From: Amanda Scholes on behalf of Planning.Responses
Sent: 09 December 2019 11:04
To: Planning Scanning
Subject: FW: 10053: Toddington Lane Littlehampton, Arun District, BN17 7PN APP/C3810/W/18/3197149 (LU/162/17/PL) Condition 14
Attachments: Toddington Lane Highway Boundary.pdf; 10053_304 Pedestrian visibility Splays.pdf

Subject: 10053: Toddington Lane Littlehampton, Arun District, BN17 7PN APP/C3810/W/18/3197149 (LU/162/17/PL) Condition 14

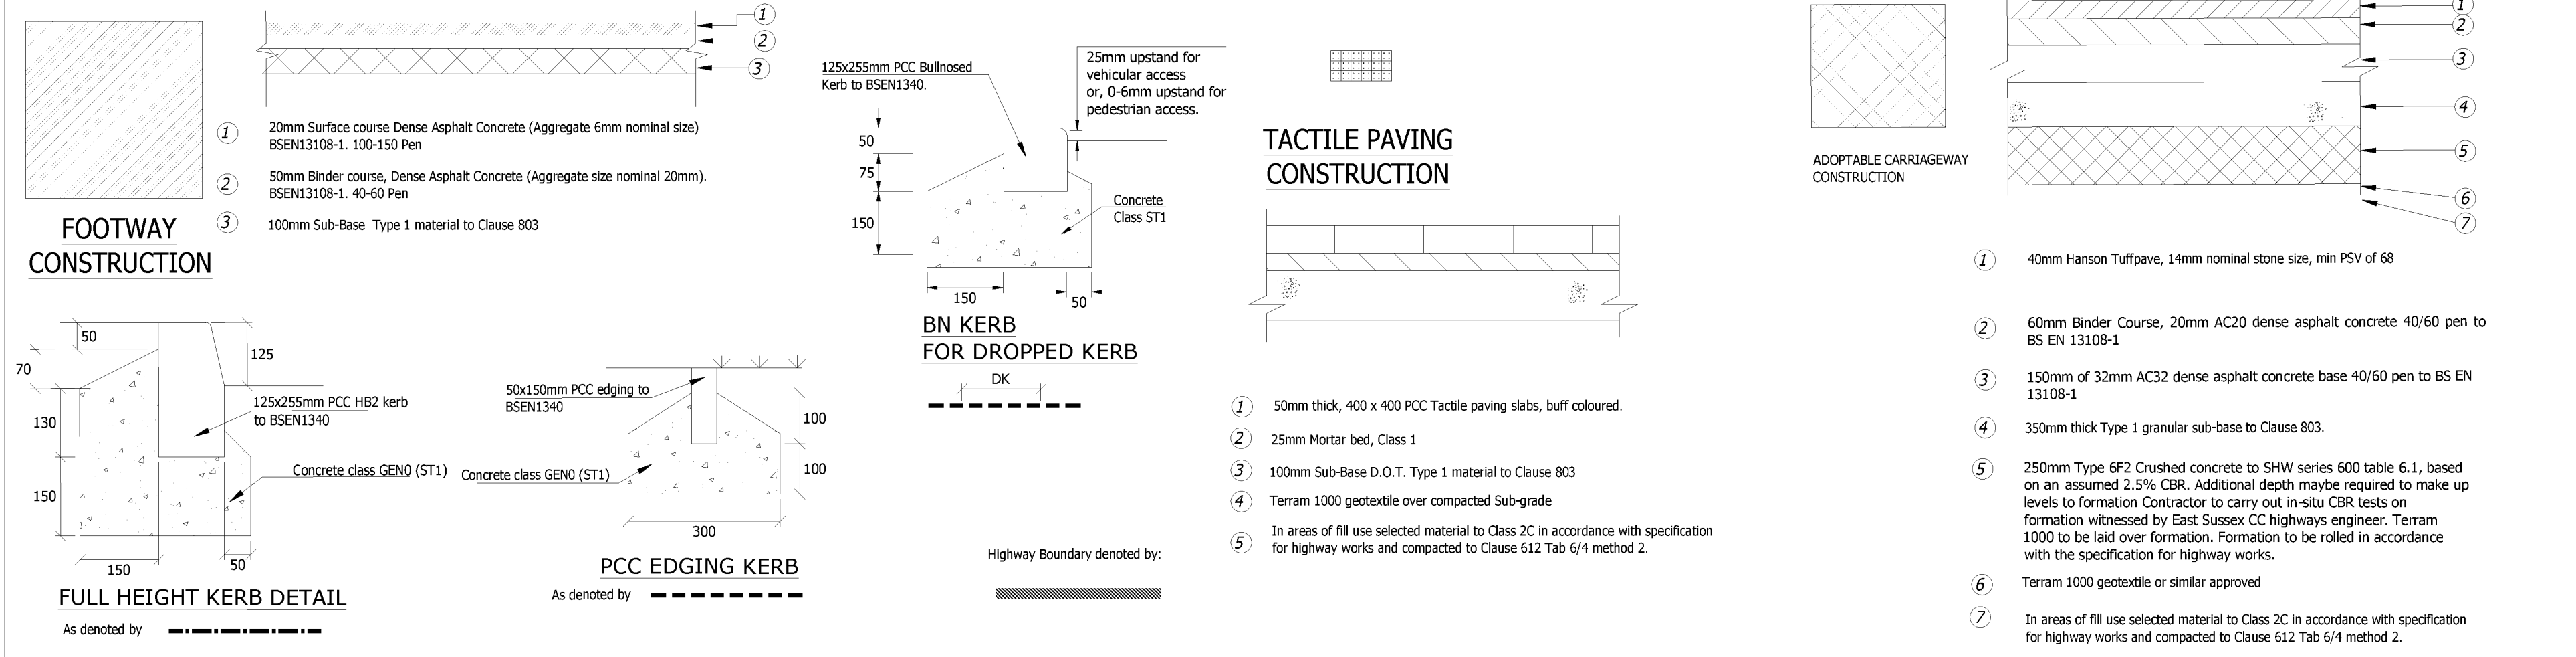
I am contacting you in regards to the development at Toddington Lane (LU/162/17/PL) and condition 14. In your comments on 15th October 2019 you asked for A visibility splay of 2.0m * 66m in both directions at the western end of the proposed footway. This was to ensure any pedestrians crossing in this location have sufficient visibility to see any oncoming cars. The 66m visibility splay is achievable looking west but not looking east.

I also note that the visibility splay asked for is from 2.0m, the proposed footway is 2m in width and it is unlikely a pedestrian would be stood on the back edge of the footway, would a visibility splay from 1.0m be acceptable as this is likely to be more reflective of a pedestrians position on the footway.

We have had a speed survey completed on Toddington Lane to assess if the 30mph speed limit you based the visibility splay on was accurate to the actual speeds. Please see the ATC data attached. The ATC indicates that the mean speed for westbound traffic is 24mph and the 85thile speed is 28mph (7 day mean). It should be noted that the position of the ATC was further to the west than the position of the proposed crossing and is likely in a location where vehicles are accelerating out of the corner. The vehicles speeds at the proposed crossing point are actually likely to be lower than 28mph.

I note that section 4 of WSCC design guide states that lightly trafficked residential roads have 85thile speeds below 37mph, can have MfS1 standards applied. As this is the case for Toddington Lane, the 66m visibility splay is likely in excess of the stopping sight distance for westbound vehicles will need to see pedestrians. Using MfS1 standards and the recorded 28mph 85thile speed there is a stopping sight distance requirement of 39m.

With the above in mind I would suggest a 1.0m * 39m visibility splay should be acceptable and allow for the crossing point to function safely. Please see update site layout with the visibility splays, I have shown 66m looking westwards as this is achievable and 39m is achievable looking east. Please note I have shown the 39m visibility splay to 600mm off of the kerb to represent the likely position of a car.
